Ardleigh Parish Council Response to National Grid Norwich to Tilbury DCO Application

Report on Proposed Route Alignment and EACN Substation Siting in Ardleigh

Date: 26 January 2026

Title:  
 Figure 7.12.F83\_VP3.14a  
 Viewpoint 3.14: Lodge Lane, Ardleigh  
 Reservoir

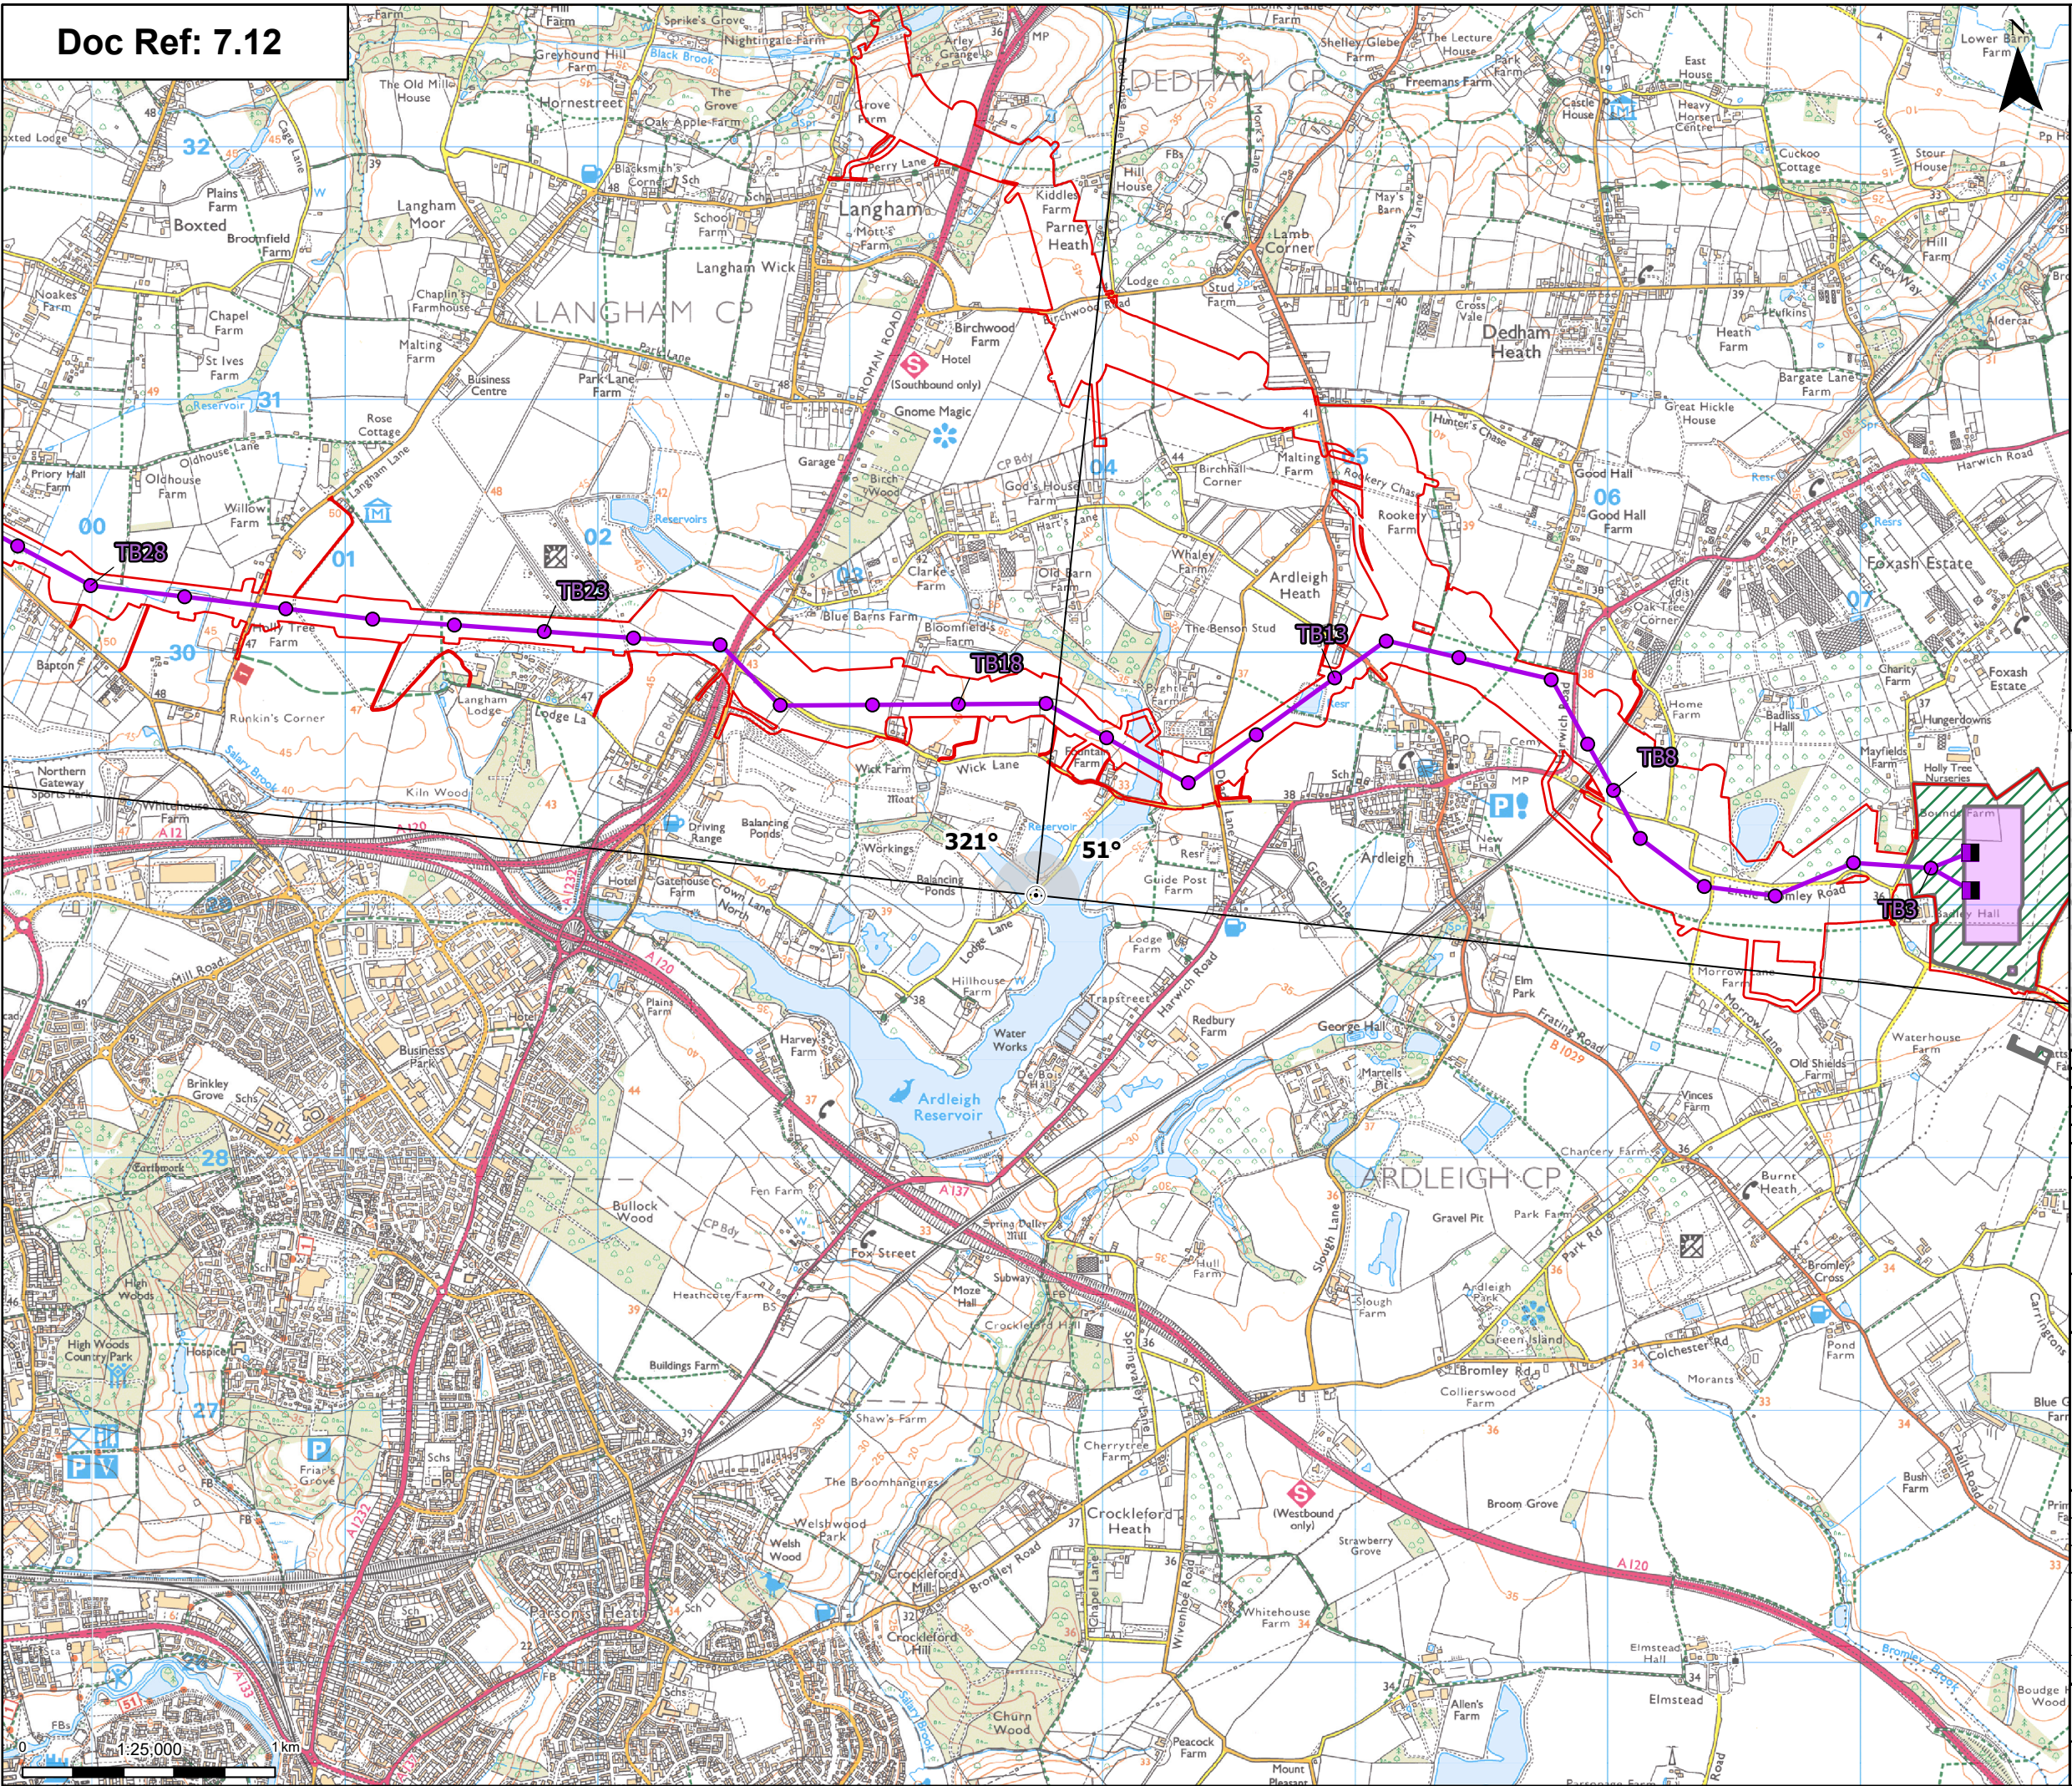
5.13 It is DCO application National Grid has only supplied visualisations for one Historic Environment viewpoint in the Parish of Ardleigh, which is “HE25”. This however shows that overhead lines would be visible from the centre on the Ardleigh Conservation Area (CA26) and from the Grade II* listed St Mary’s Church (1112060). A section from the HE25 image is copied below, with an arrow added here (in orange) to show the overhead lines that would be introduced to the setting.

Drawing Number:
 10059280-ARC-EHR-ZZ-DR-ZZ-00401

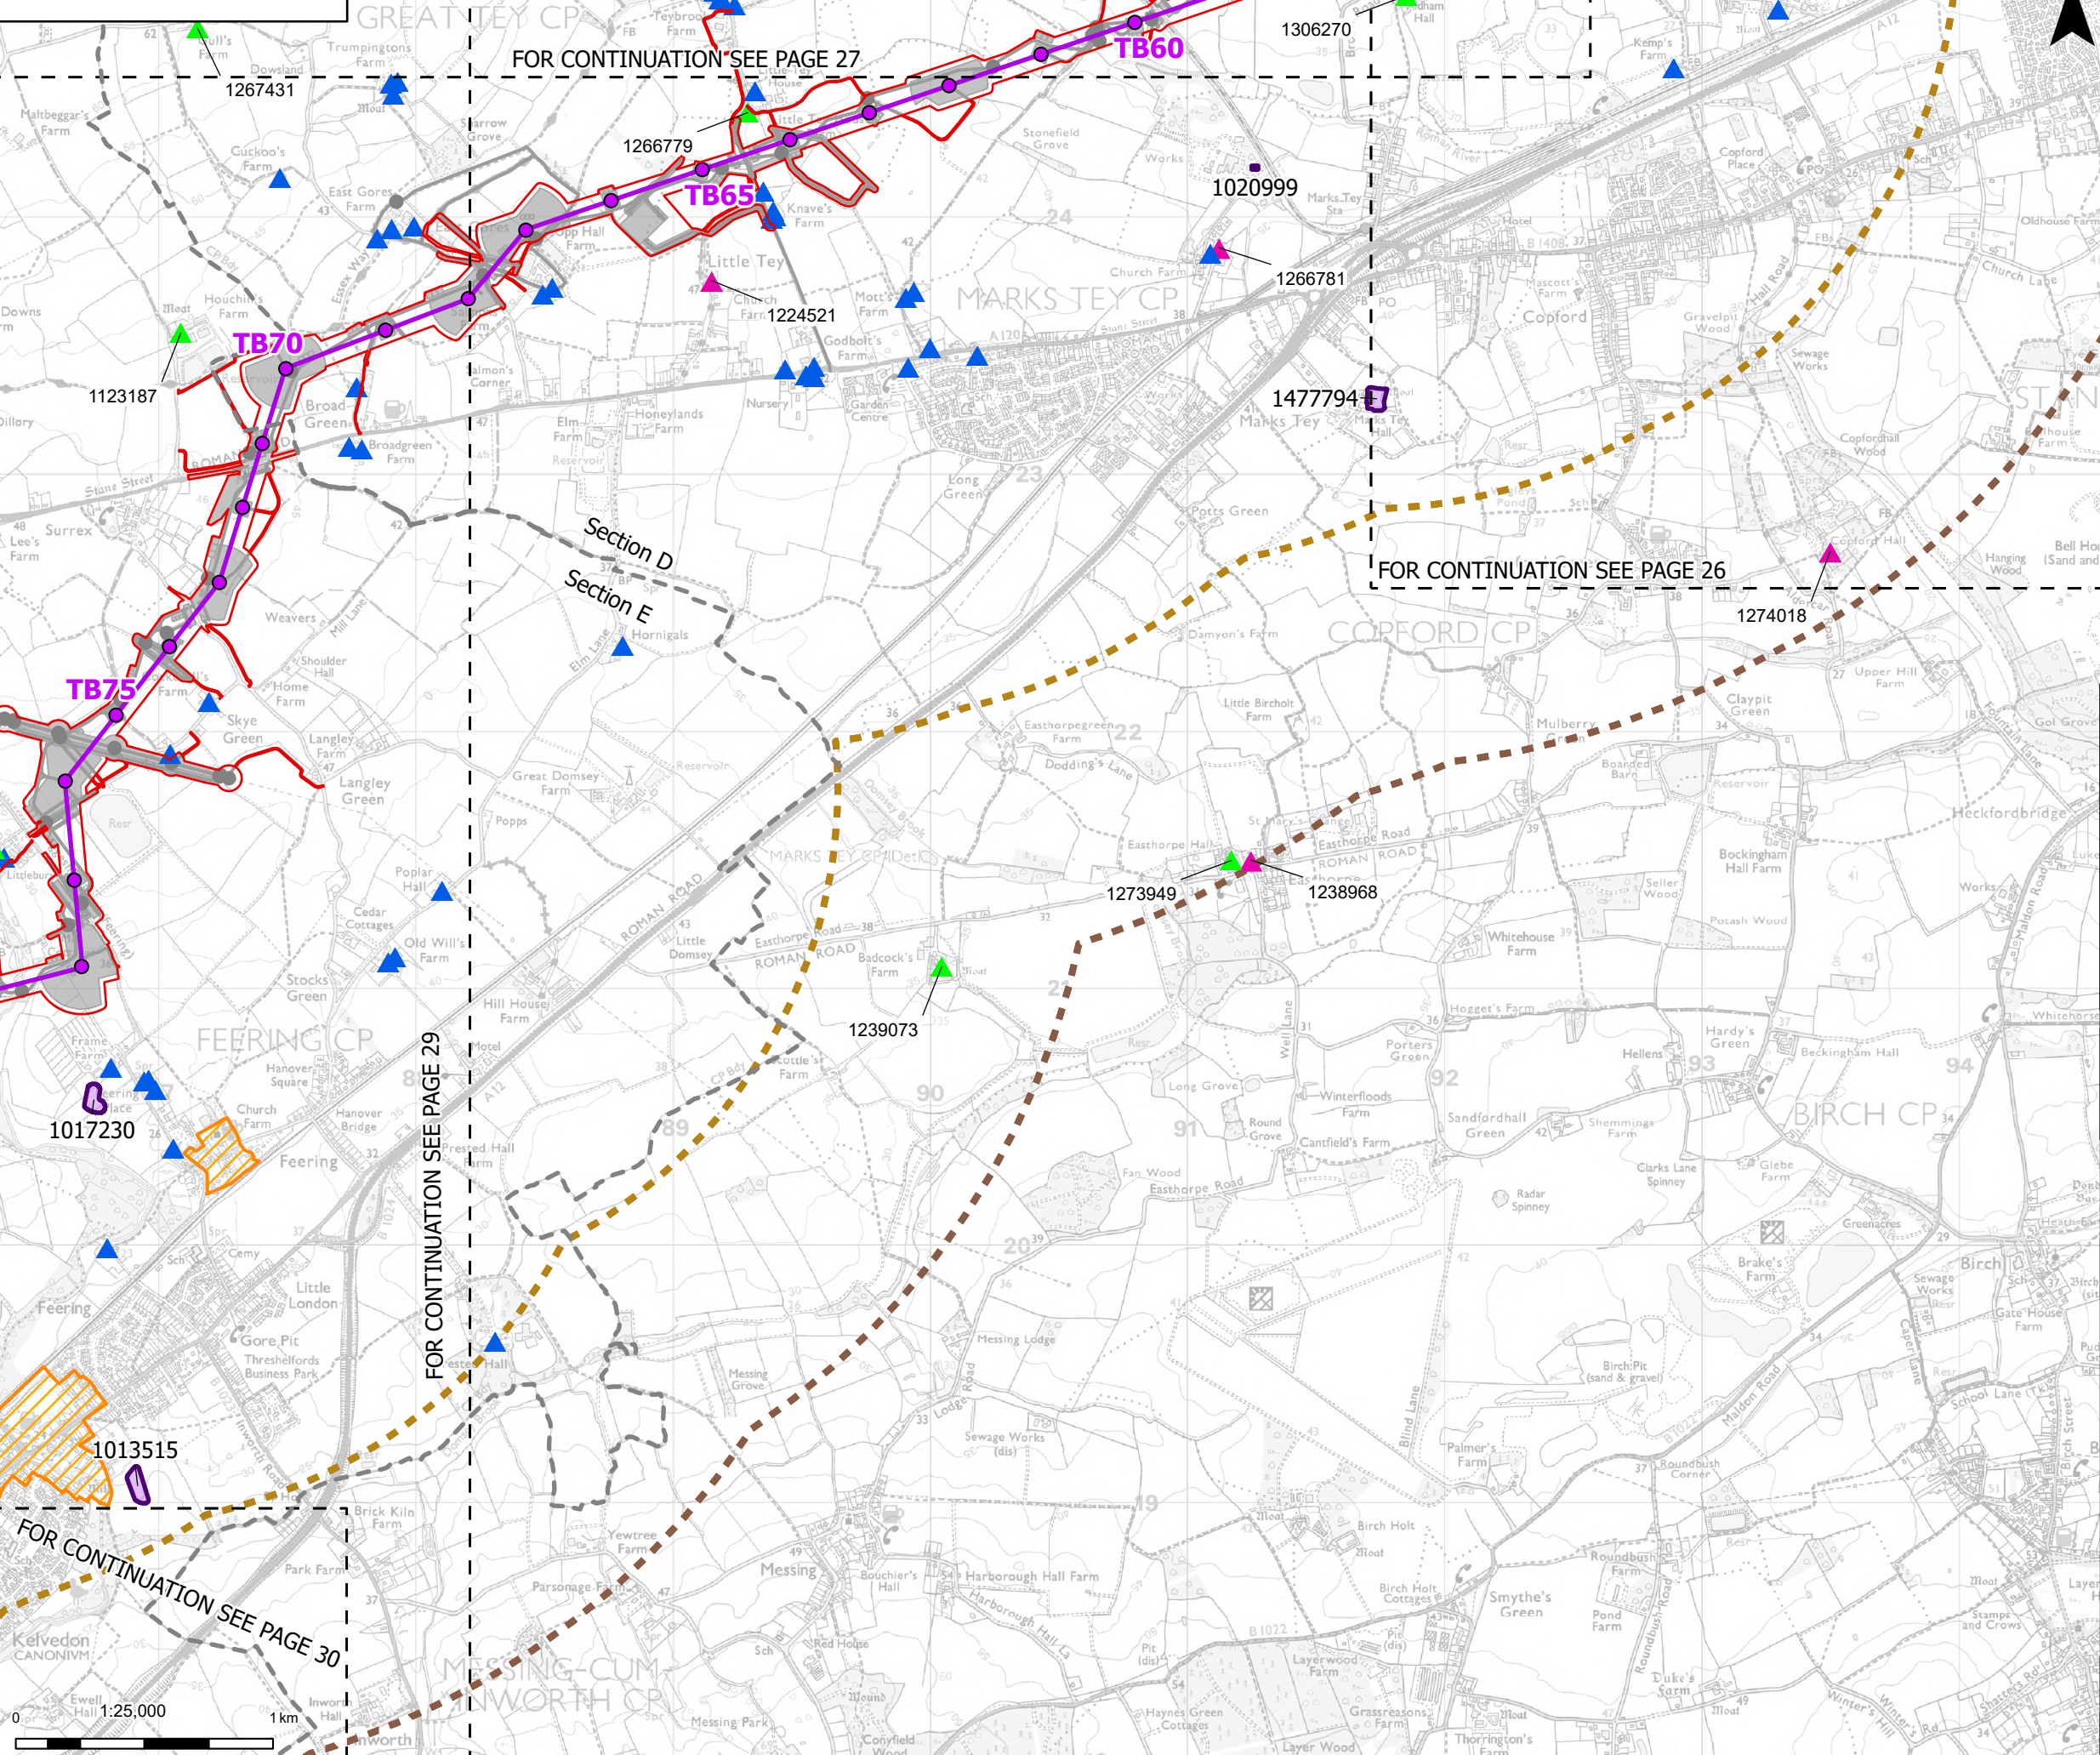
- 5.6 The issue is clearly demonstrated in *“Figure A11.1: Historic Environment Designated and Non-Designated Heritage Assets: Drawing No. 10059280-ARC-ELS-ZZ-DR-ZZ-00188”*, as presented by NGET at the 2024 Statutory Consultation and copied here as Appendix C-1. Supplementary information is provided in Appendix C-2, which was produced for the report *“Ardleigh PC submission to NG- Historic Environment”* submitted for the Statutory Consultation in July 2024. The additions came from information in reports supplied by NGET for the Statutory Consultation and from information held locally.

- 5.7 Appendix C-3 and Appendix C-4 are copies of the designated and non-designated heritage assets maps supplied by NGET as part of the DCO application.

- 5.8 Unfortunately, the DCO submission does not include a single map showing both designated and non-designated heritage assets even though such a map was produced for the Statutory Consultation. This makes it difficult to appreciate the full impact on heritage assets. The issue was raised with NGET in November 2025 and the following response received: *“...We have not produced a singular*

5.9 The non-designated heritage assets map shown in Appendix C-4 also does not consider the additional assets highlighted by Ardleigh PC in its Statutory Consultation submission, as shown in the modified map in Appendix C-2. These are the Areas A & B, as identified in EAA Report 90 and additional information on the Roman Roads 3033/3035 and MEX9020 which intersect the proposed EACN site. (MEX9020 is the reference number used in the EACN Substation Geophysical Survey Report obtained by NGET.)
